# Rezoning Transportation Analysis

Petition Number: 2023-042

**From:** Jake Carpenter, PE  
Jacob.carpenter@charlottenc.gov  
980-221-5675

Date	Description
7-26-23	First Review (PM)
8-23-23	Second Review (PDM)

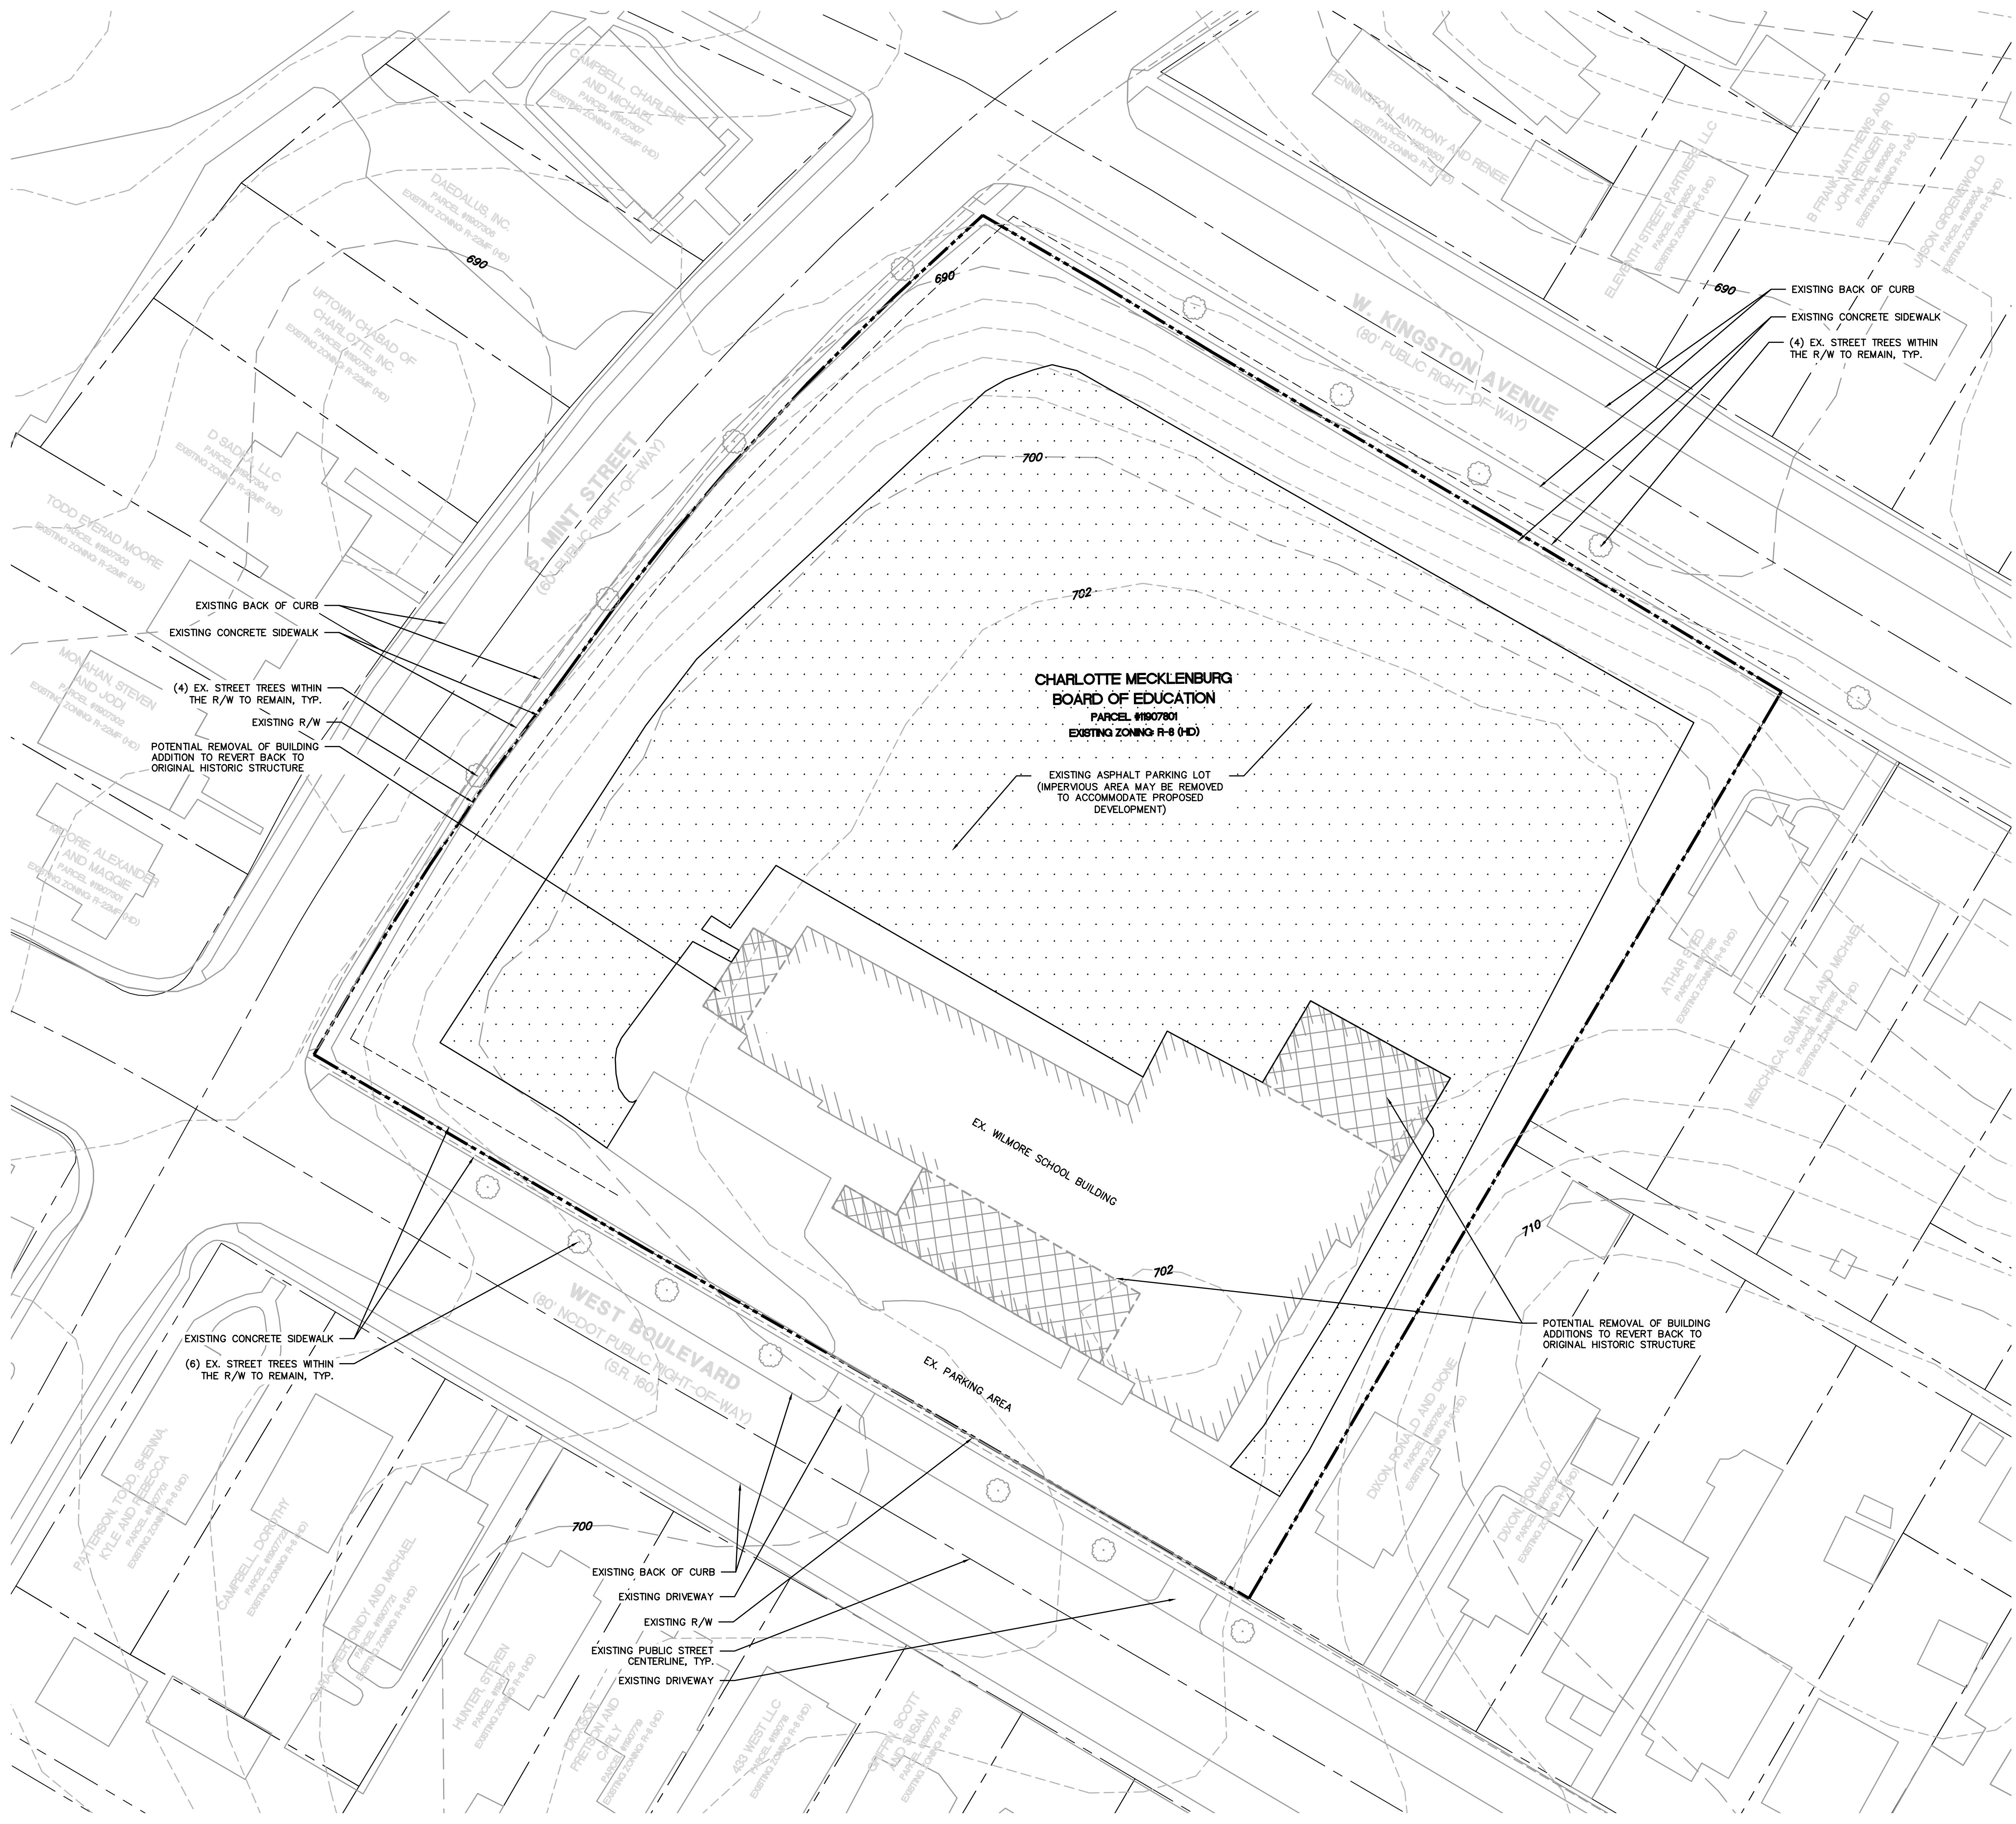
4. **Outstanding Comment from 7.26.23:** In coordination with NCDOT, revise site plan and conditional note(s) to commit to construct bicycle facilities by installing a 12' multi-use path on West Boulevard to meet the Council-adopted Charlotte BIKES Policy. Charlotte Streets Map calls for buffered bike lanes, NCDOT will not allow buffered bike lanes on West Boulevard. Multi-use paths maintained by the City shall meet ADA/PROWAG requirements.

5. **Outstanding Comment from 7.26.23:** Revise site plan to install the proposed streetscape off the future back of curb located 30' from the centerline.

7. **Outstanding Comment from 7.26.23:** Per coordination with NCDOT, the site access on West Boulevard needs to be right-in ONLY with a right turn lane.

8. **Outstanding Comment from 7.26.23:** Per coordination with NCDOT, remove this site access along West Boulevard.
